CITY OF ALBUQUERQUE

April 30, 2010

**Re: West Mesa High School Parking Lot Grading and Drainage Plan
Engineer's Stamp dated 4-13-10 (J10/D005)**

Profile Report **Engineering Profile - PROFILE 4 (stormcad parking lot.stc)**

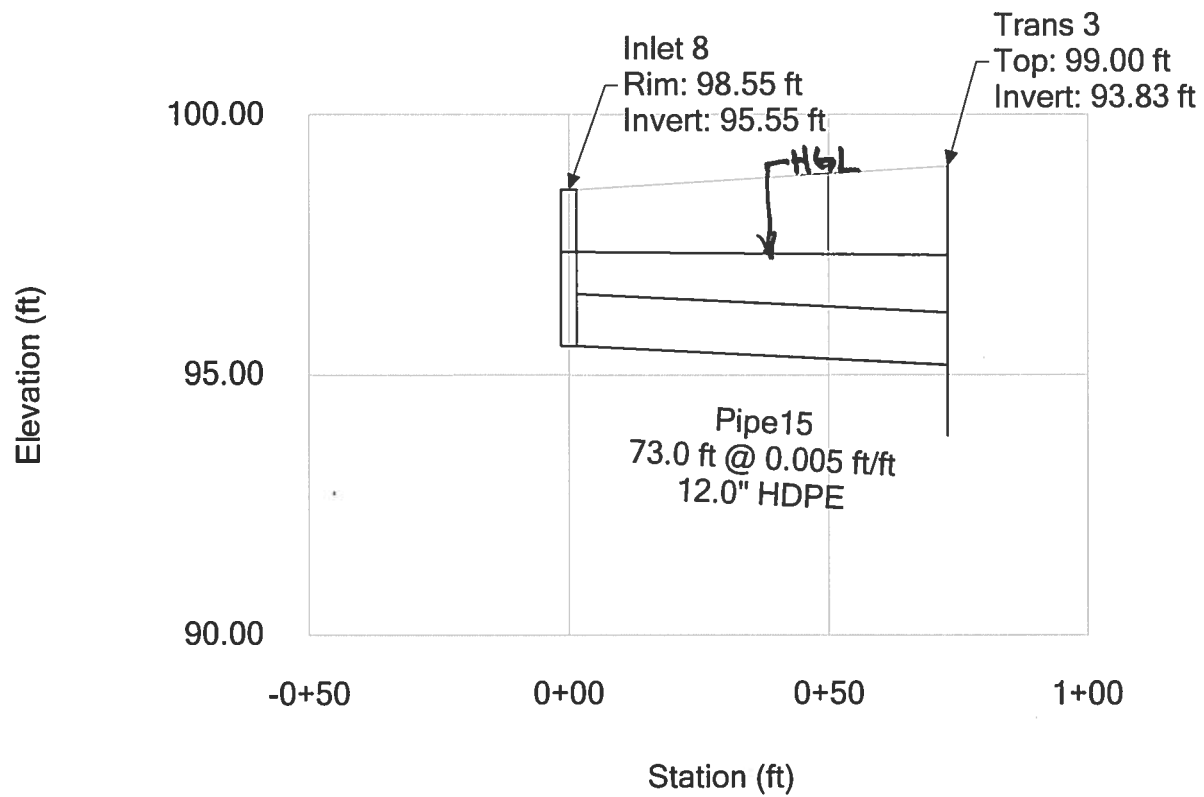
Please verify the inverts for the existing and proposed storm drain. There may be an inconsistency between the StormCad data and the Grading Plan.
